Development Control  
Ribble Valley Borough Council

**App no: 24.0999**

**Address: Rossendale House York Street Clitheroe**

**Proposal: Proposed change of use from nursery to eight flats (C3) comprising three two-bedroom units and five one-bedroom units. Amendments to details approved under 3/2023/0827.**

Title:  
Proposed Site Plan

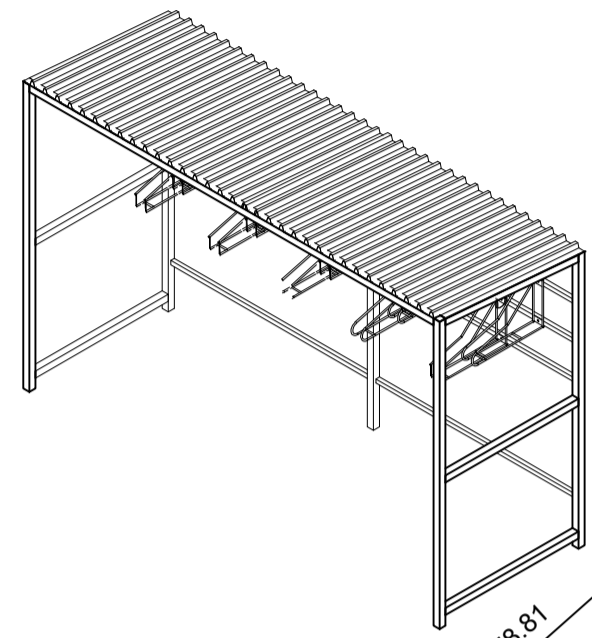
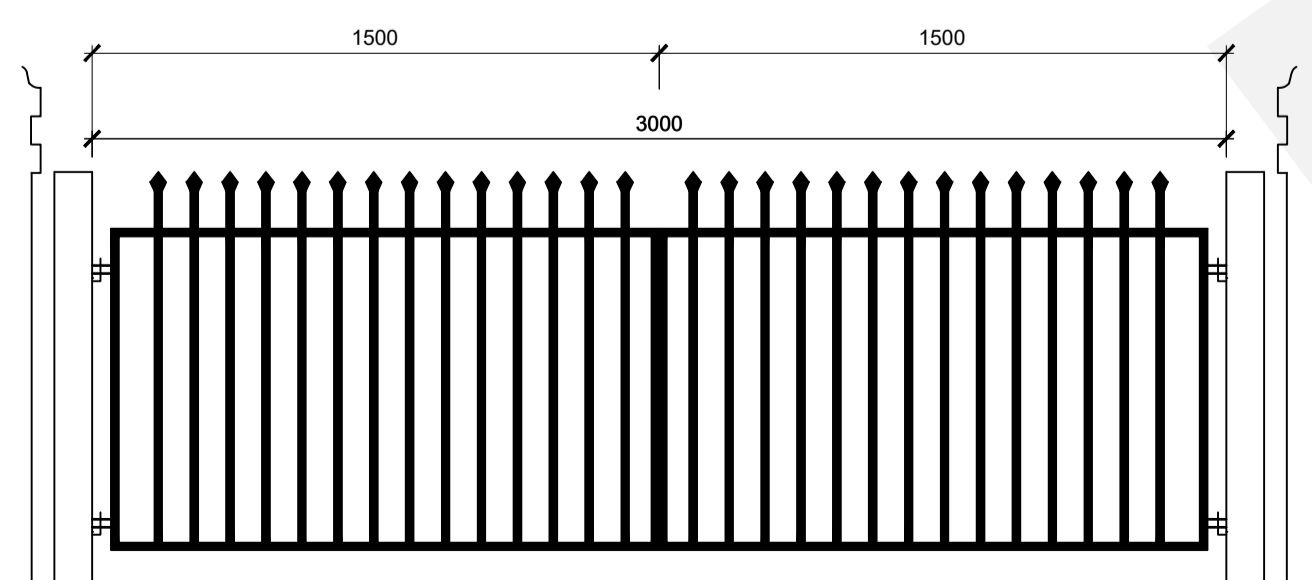
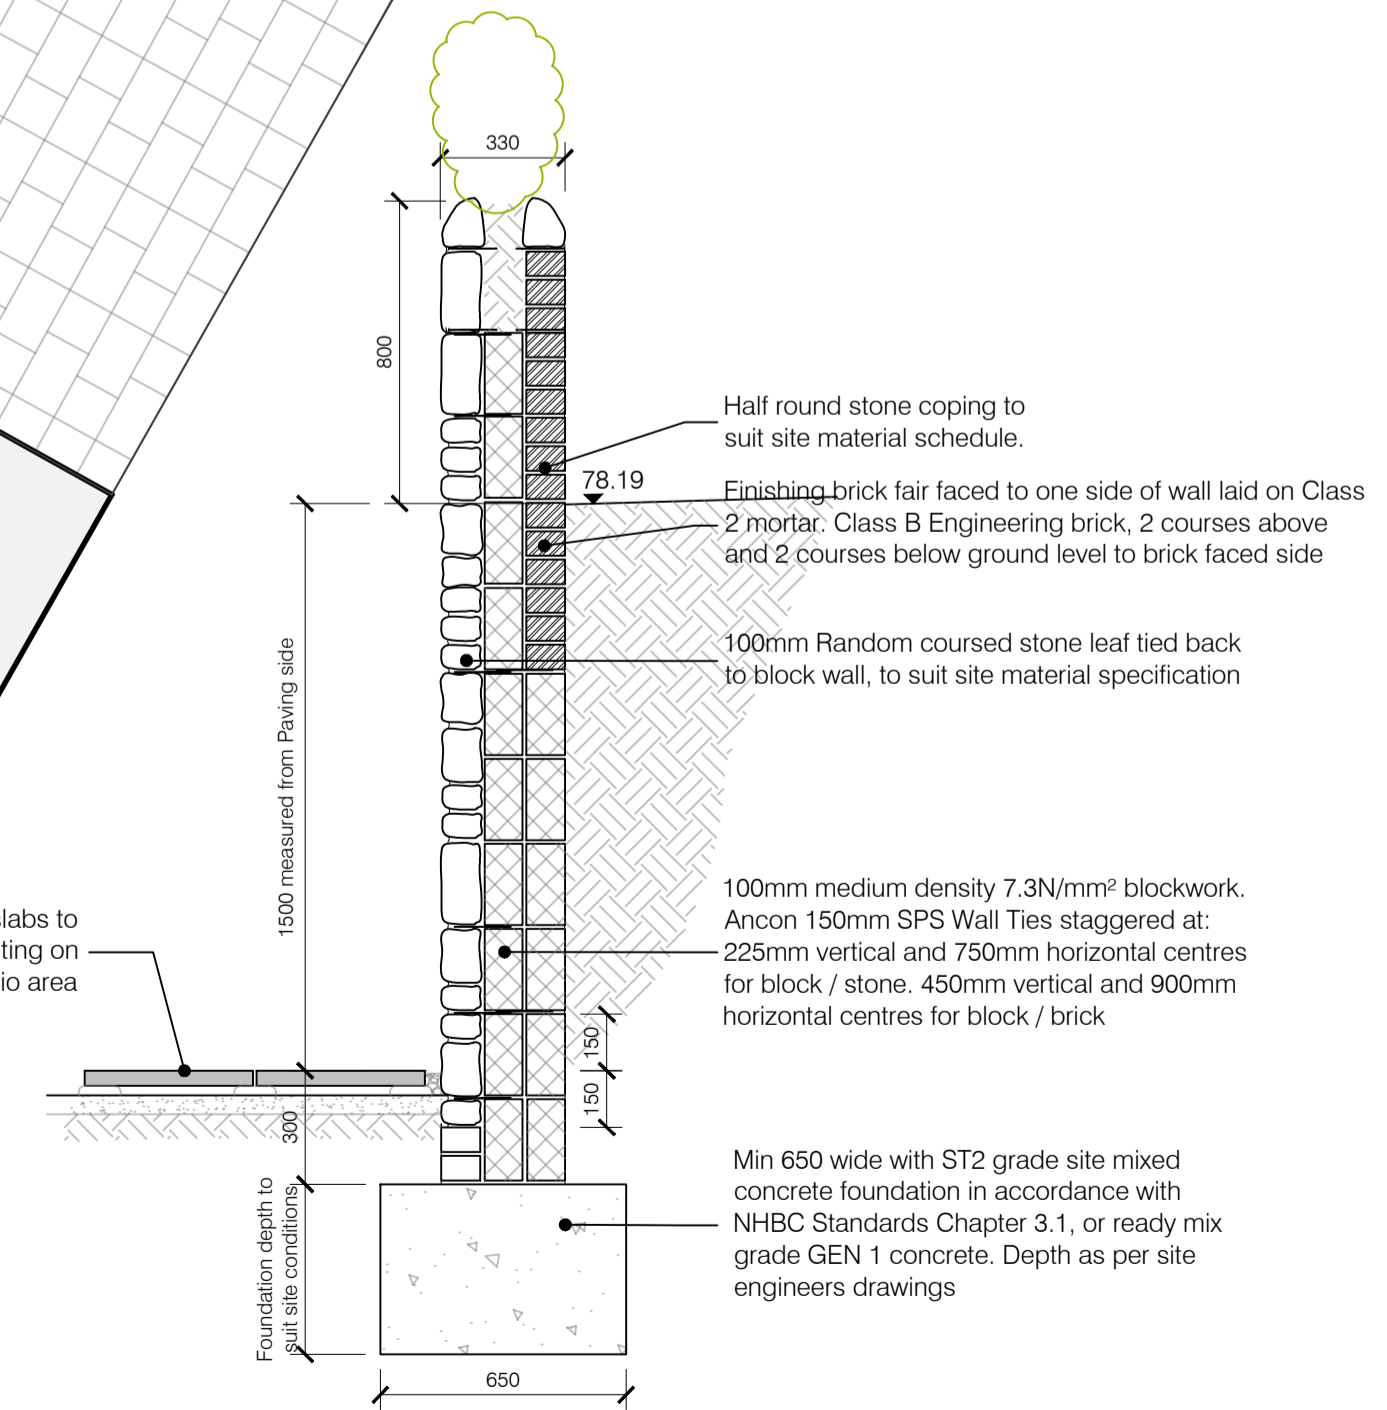
A new stone boundary wall is proposed for flats 1 and 2 (garage/basement). The existing vehicle access off York Street is to become a pedestrian and cycle access only. Bin storage is to be provided adjacent to the boundary wall with York House.

The cycle store is proposed adjacent to the existing retaining wall to the ground floor amenity space to flat 5.

Lancashire County Council acting as the Highway Authority does not raise an objection regarding the proposed development and are of the opinion that the proposed development will not have a significant impact on highway safety, capacity or amenity in the immediate vicinity of the site.

1. The construction traffic management plan submitted for application 24/0534 shall be adhered to throughout the construction phase. Reason: For highway safety.
2. The scheme for the site access and off-site highway works shall be completed prior to the first occupation of the development hereby permitted. Reason: For highway safety.
3. No building or use hereby permitted shall be occupied or the use commenced until the shared cycle storage plan providing 10 cycle stands for the residential units has been installed in accordance with the submitted details. These cycle facilities shall thereafter be kept free of obstruction and available for the parking of bicycles only at all times.  
Reason: To allow for the effective use of the parking areas and to promote sustainable transport as a travel option, encourage healthy communities and reduce carbon emissions
